**Formal Objection to State Significant Development SSD 96505456 – Cammeray Seniors
Living 19–23 Rosalind Street, Cammeray NSW 2062**

Attention: Najeeb Kobeissi
Senior Planning Officer, Social and Diverse Housing Assessments

We object to the above State Significant Development on the grounds of unreasonable amenity impacts on adjoining residential properties.

SECTIONS

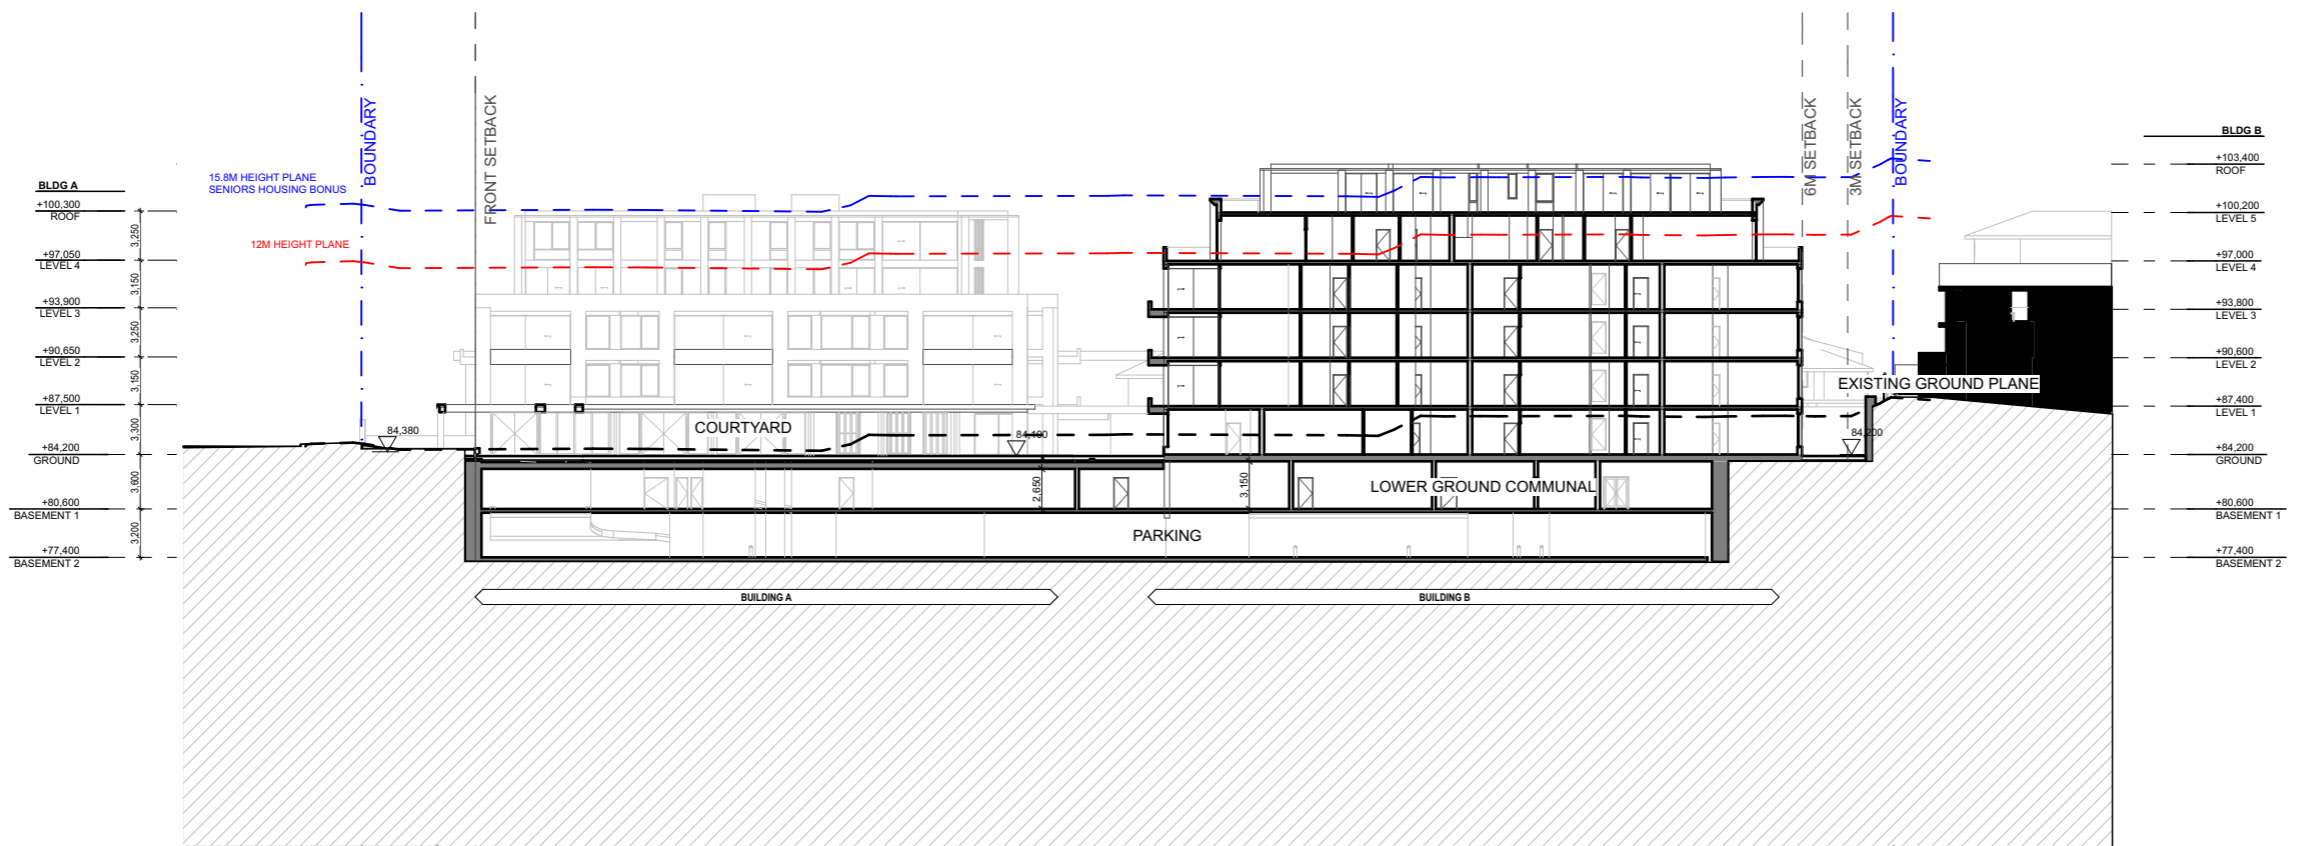
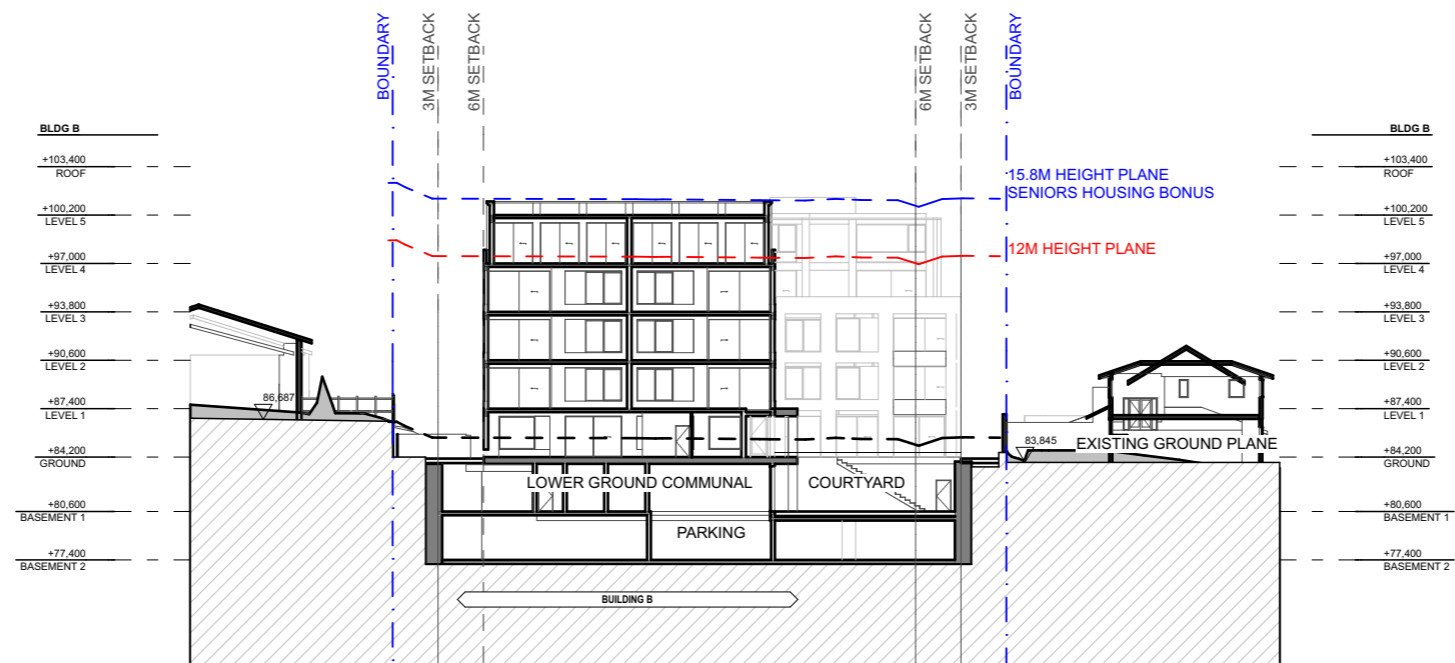
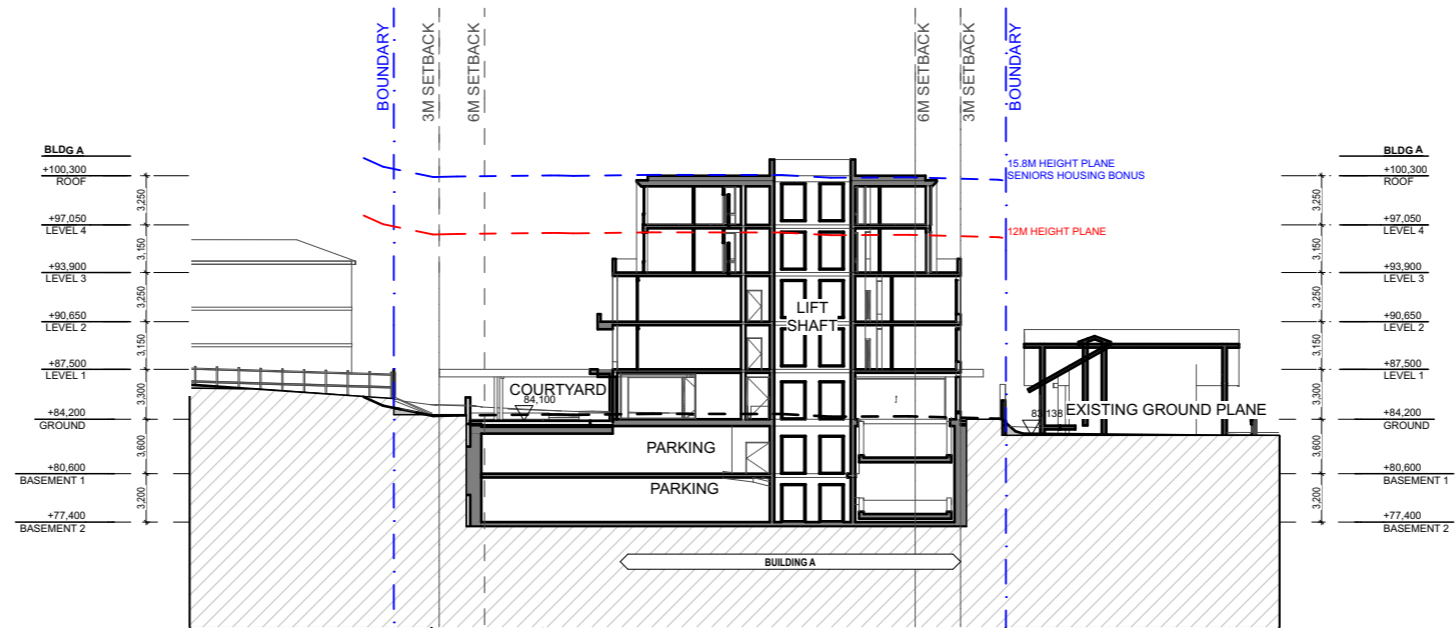
Building B has a proposed height of **18.36 metres**, exceeding the **15.8 metre** maximum height limit by **2.56 metres**, with the roof and lift/stair overruns reaching approximately **19.34 metres**. The argument that lift and stair structures should be excluded from height calculations is inconsistent with the intent of maximum height controls.

The introduction of a **sixth floor** effectively adds an additional storey to maximise development yield and attain harbour and district views. The position in Building B at the rear of the site does not negate its impact, it just shifts it to neighbouring homes on the Western and Southern Boundaries including 5/199 West Street. This floor should be **removed entirely**, and additional setbacks applied to levels 4 and 5 along the Western boundary.

Removal of 6th floor on building B to comply with maximum allowed height of 15.8 metres and, additional setbacks applied on the western boundary to protect amenity impacts and allow a transition in scale with lower density neighbours.

DRAWING TITLE
LOWER GROUND - PROPOSED PLAN
 DRAWING NUMBER
 DA-101
 REVISION
 A

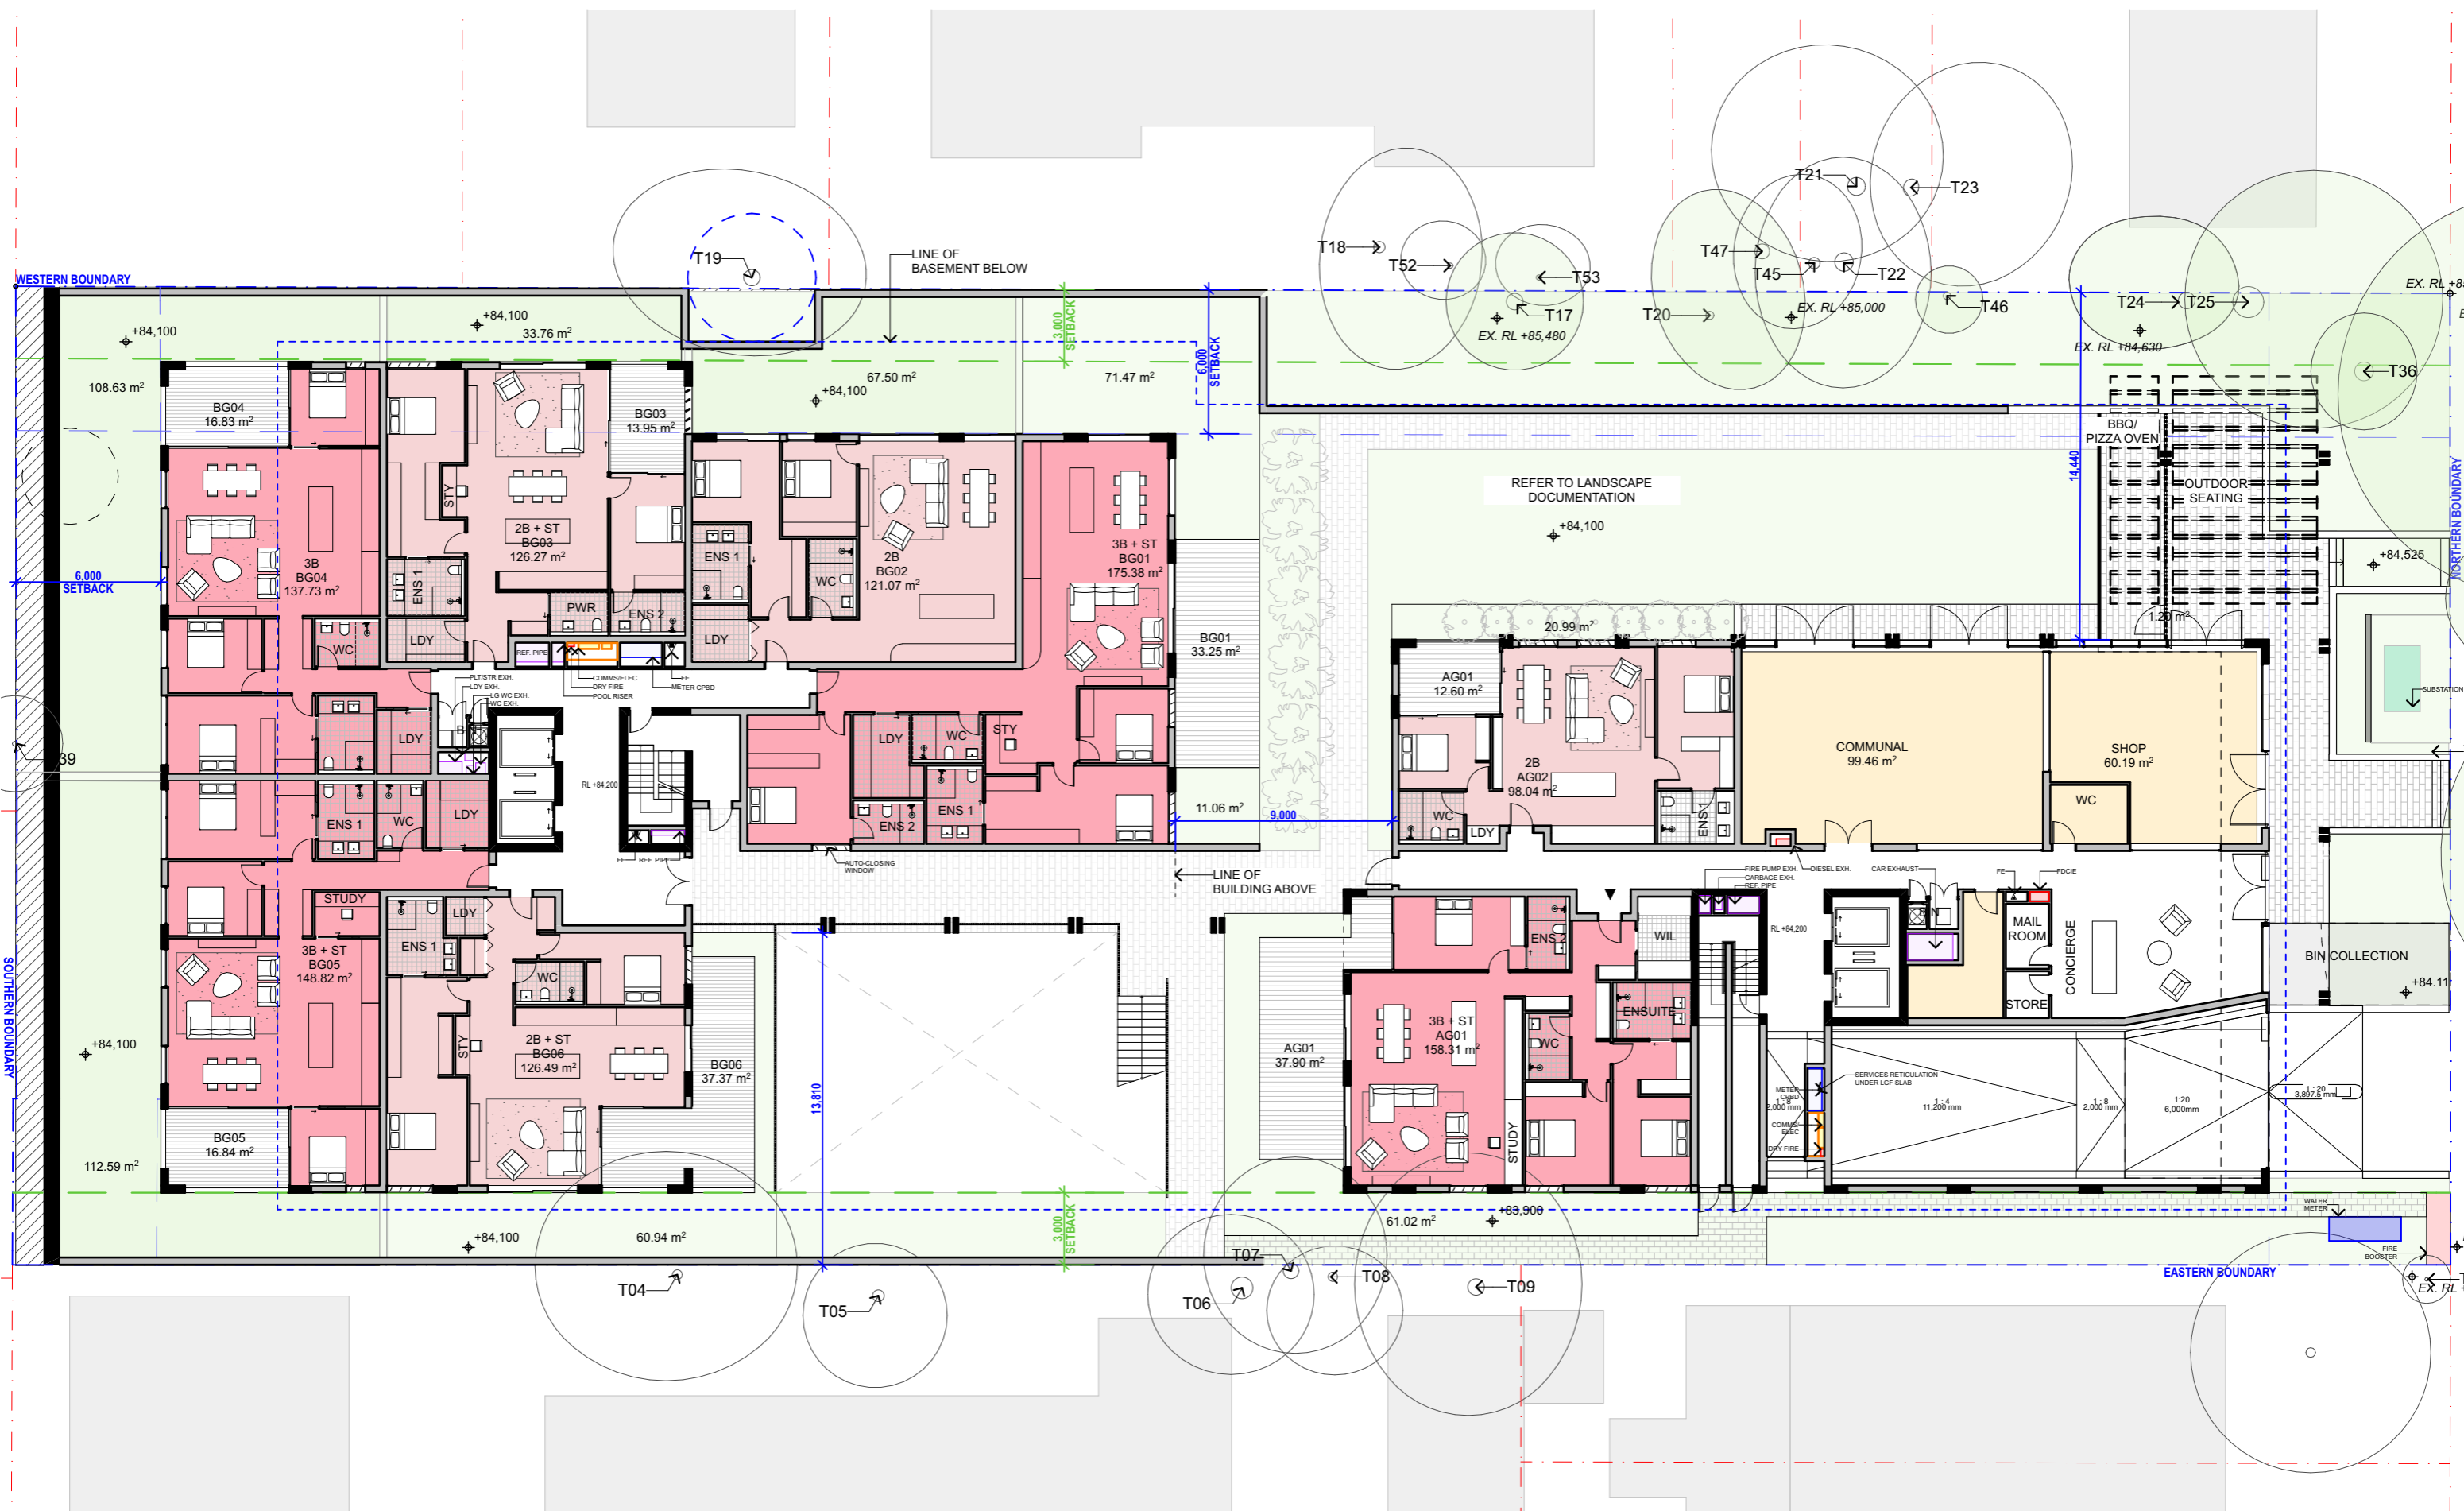
A plant room is located at the lower level of Building B adjacent to 199 West Street. Plant rooms are a known source of continuous noise and exhaust emissions.

All mechanical exhaust and plant noise should be **vented at roof level**, well away from neighbouring dwellings, consistent with best-practice design. As proposed, noise and vehicle fumes from the garage and plant will directly impact the bedrooms and living areas of **the adjoining townhouses**, creating an unacceptable acoustic and air quality environment.

Appropriate changes to the plant room on the lower ground floor of building B.
